# DELEGATED HOUSEHOLDER DECISION

**Address:** 21 PAMELA GARDENS EASTCOTE PINNER

**Development:** Erection of a wraparound dormer to rear and sides, installation of 1 front roof light and removal of chimney to create habitable roof space.

**LBH Ref Nos:** 6831/APP/2025/1858

PROJECT
21 PAMELA GARDENS
PINNER
HA5 2QU
DRAWING TITLE
PROPOSED PLANS
AND ELEVATIONS
SCALE 1:50@A1
DRAWING No
21PG-301-02H
DATE JUN '24

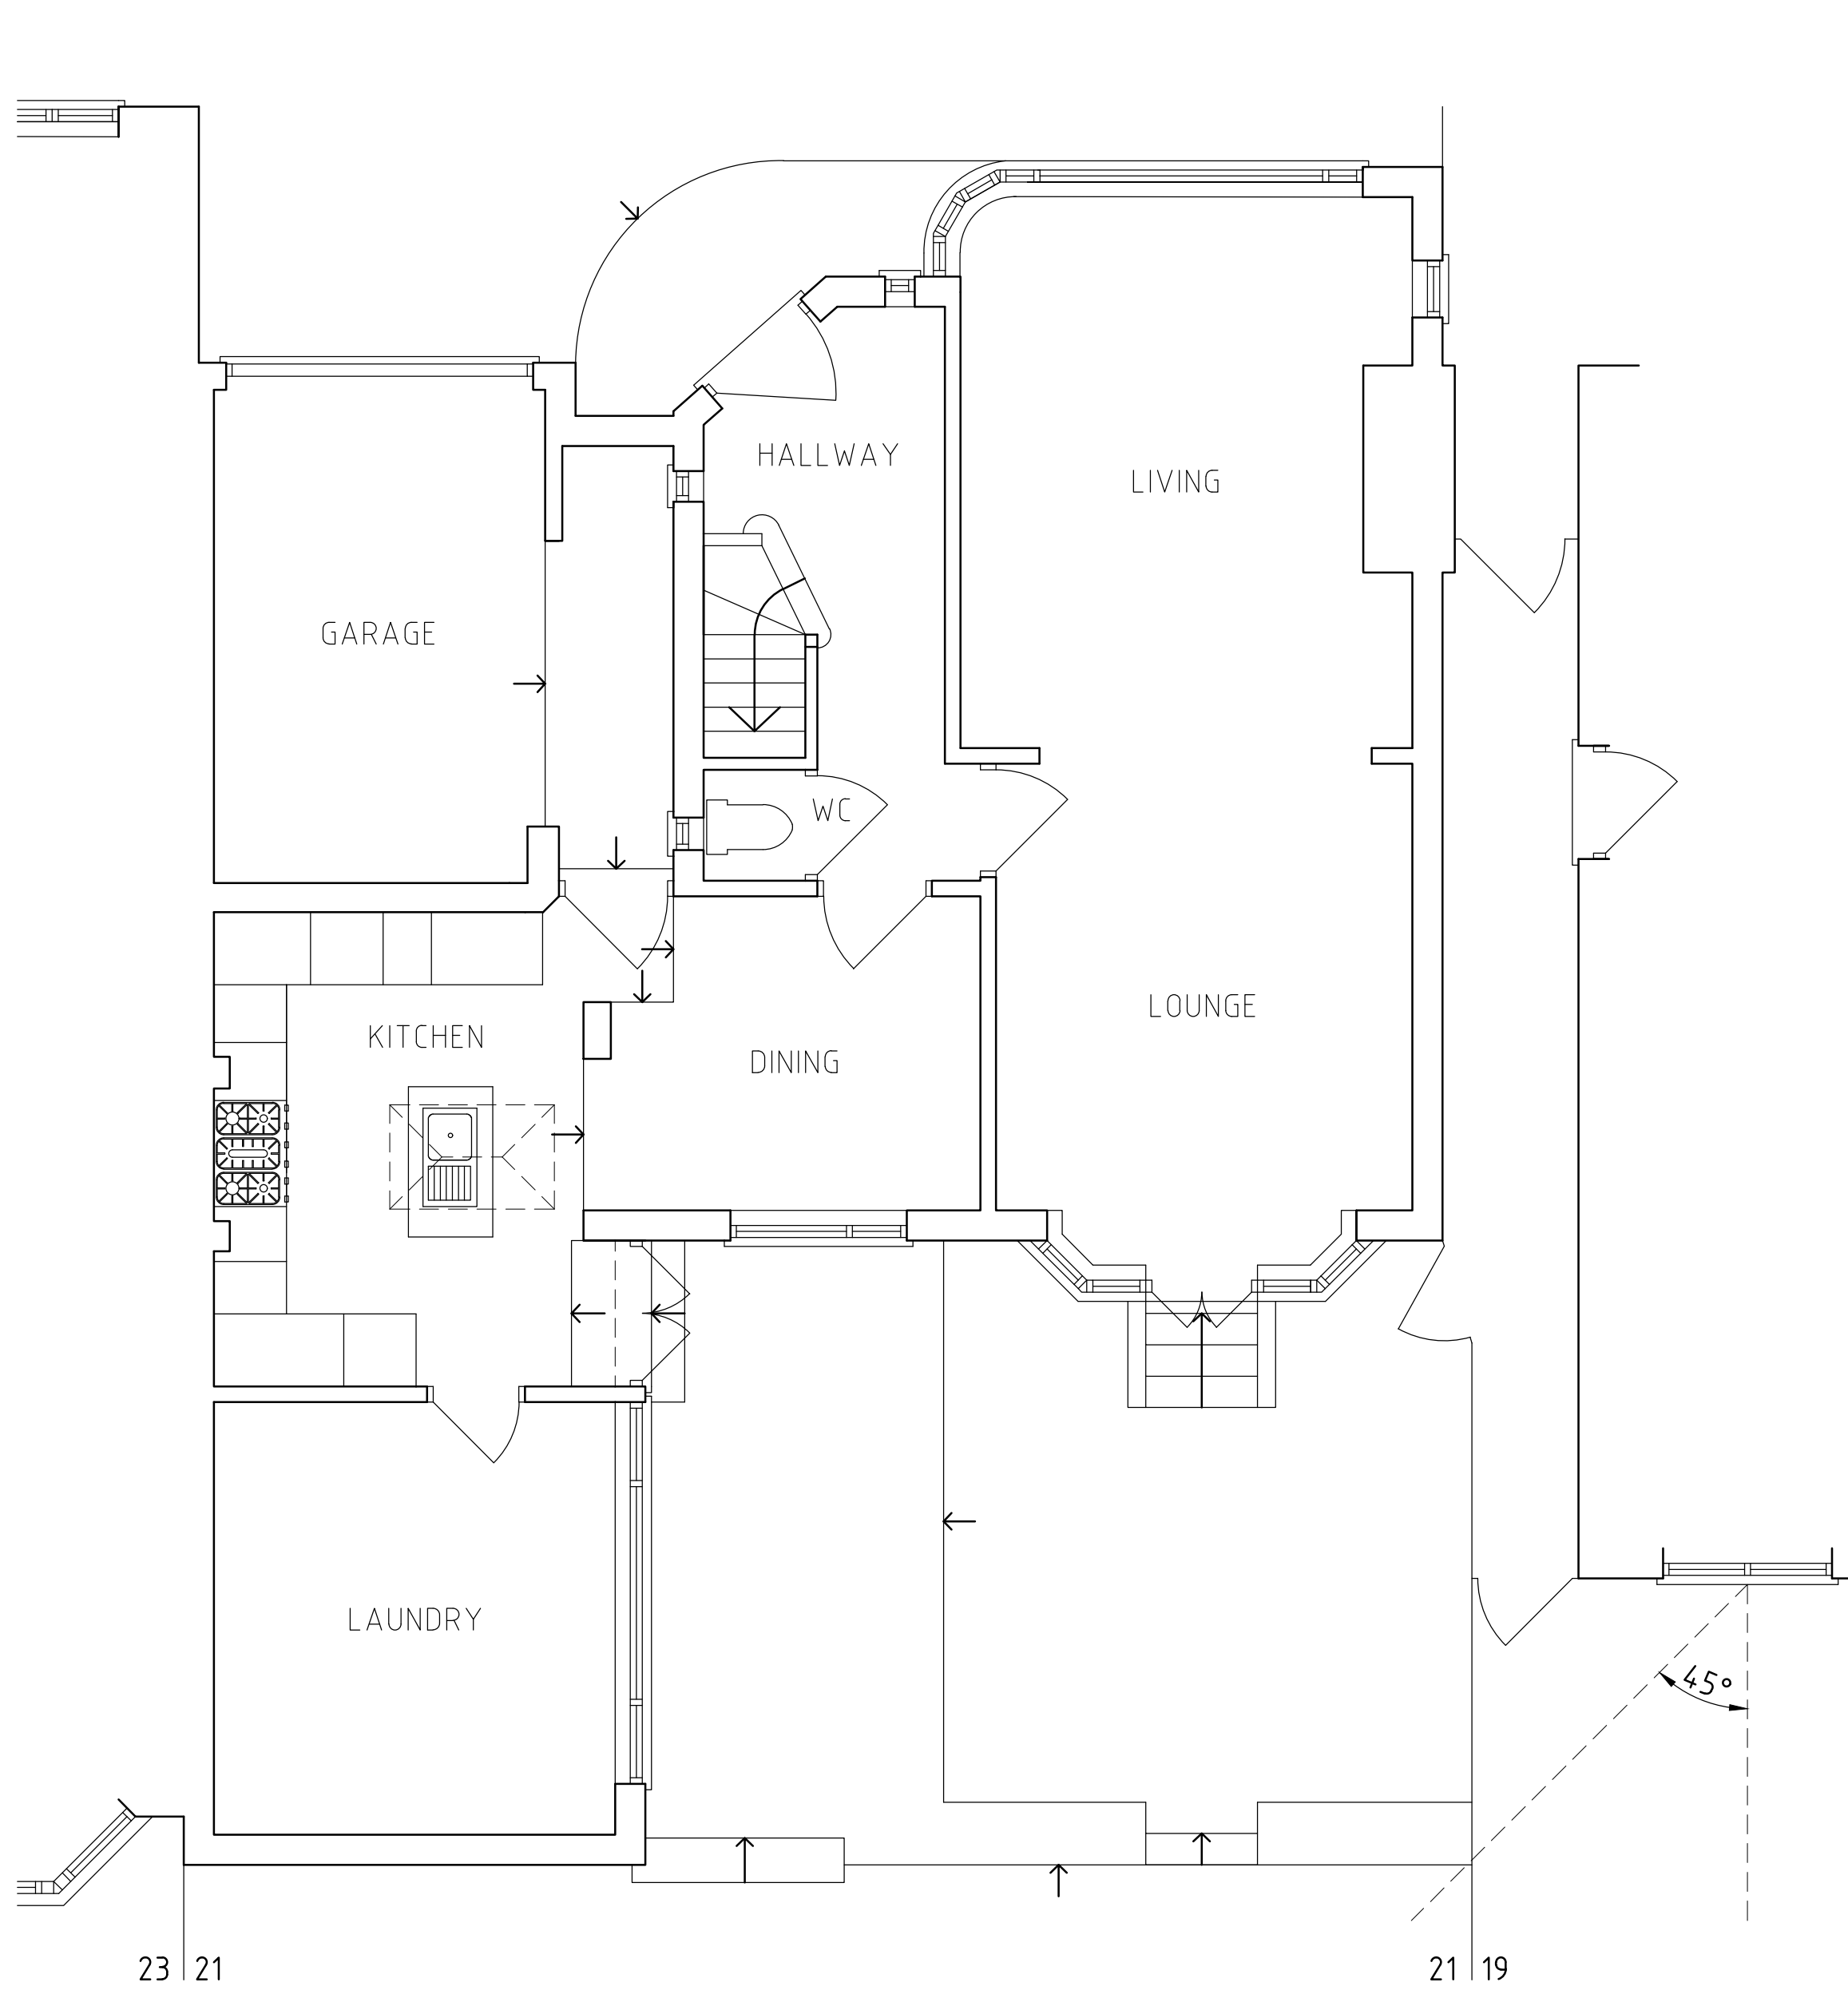
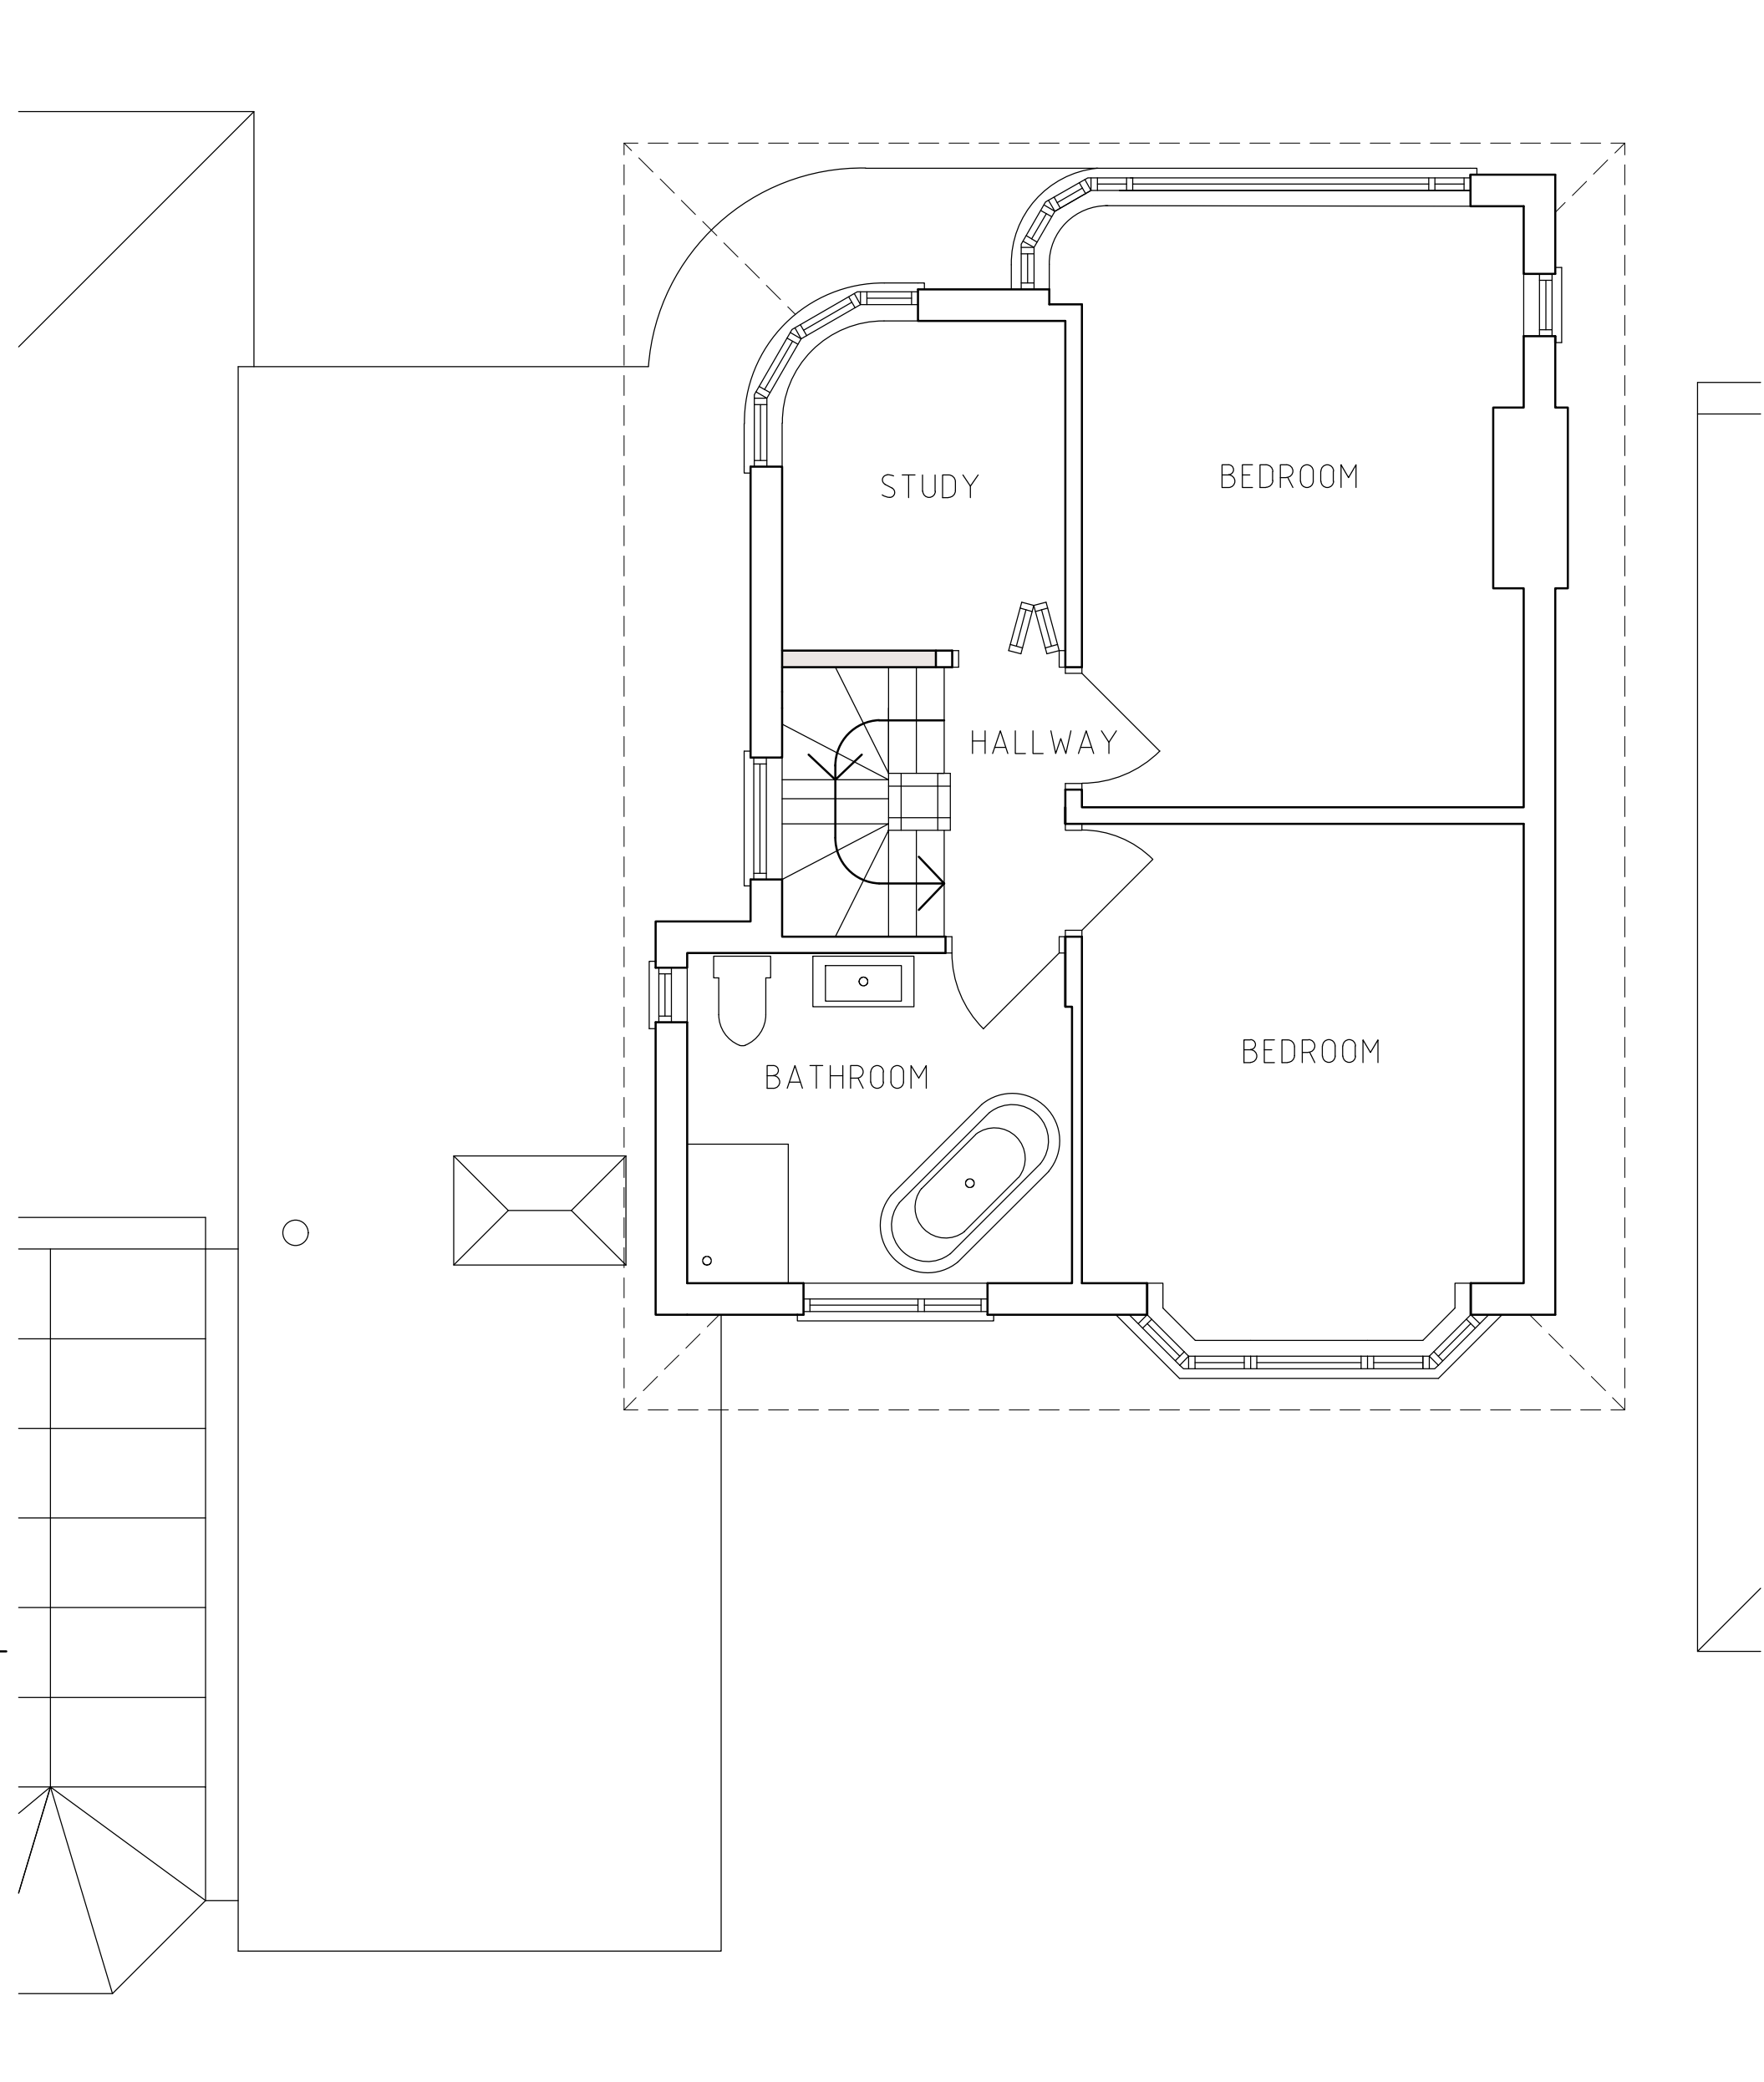
The proposed development seeks to construct a full-width wraparound dormer spanning the entire rear roof slope and projecting noticeably onto the side roof plane. The dormer occupies a substantial proportion of the original roofscape, adding considerable bulk and compromising the building's distinctive hipped roof profile.

A wrap around dormer with the width of 6m and height of 1.9m and a depth of 2.9m is proposed which would result in an overspill and the formation of side dormers. The proposal involves extensive alterations to the roof profile which involve an increase to its width and make it appear discordant and at odds. The Local Plan states that dormers should not be overly large, and 'box-like' dormers to the side of the property or in protected areas will be unacceptable. As a general rule, dormers should not be more than two-thirds the width of the roof face of the property. They should be centrally positioned, set down below the ridge of the roof, and set up from the eaves.

Whilst they would be set in above the eaves by 1m and down from the ridge by 0.5m, they would fail to appear subordinate to the main house and would be of a significant bulk and massing, covering more than two-thirds of the width of the roof face on each side. These would be located close to the property's frontage and prominent on the street and appear at odds, especially given

In design terms, the dormer fails to draw from, or respond to, the architectural language of the host dwelling. The fenestration is of a standard domestic appearance with no reference to the building's characteristic horizontal emphasis or curved detailing. Its scale and positioning result in an unbalanced roof profile that disrupts the carefully proportioned elevations.

The design, width, bulk, and massing of the dormers mean that they would significantly alter the roof form when viewed from the street, and overall, it is considered that they would cause unacceptable harm to the character and appearance of the area. The property is an art deco and in a conservation area whereby it is paramount that properties are designed of a good quality and standard and preserved. Given this, the visual harm caused by the wrap around dormer on the property and the scale and massing of the side dormers cannot be accepted.

The dormer overspill to the sides causes overbearing issues as the gap is a paramount feature of the properties in the area. The visual harm is considered sufficient to justify a refusal of planning permission.

The proposed wraparound dormer, by reason of its excessive size, scale, bulk, height, and design would fail to harmonise with the architectural composition of the original dwelling and would be detrimental to the character, appearance, and visual amenities of the street scene and the surrounding area. The proposed development, by reason of the wrap around dormer and overspill to the side, its proximity to the neighbouring properties and the reduction of the prevailing gap space, would result in a form of development that would cause less than substantial harm to the conservation area without any notable public benefit. Therefore, the proposal would be contrary to Policy D3 of The London Plan (2021), Policy BE1 of the Hillingdon Local Plan: Part One - Strategic Policies and Policies DMHB 4, DMHB11, DMHB12 and DMHD1 of the Hillingdon Local Plan - Part
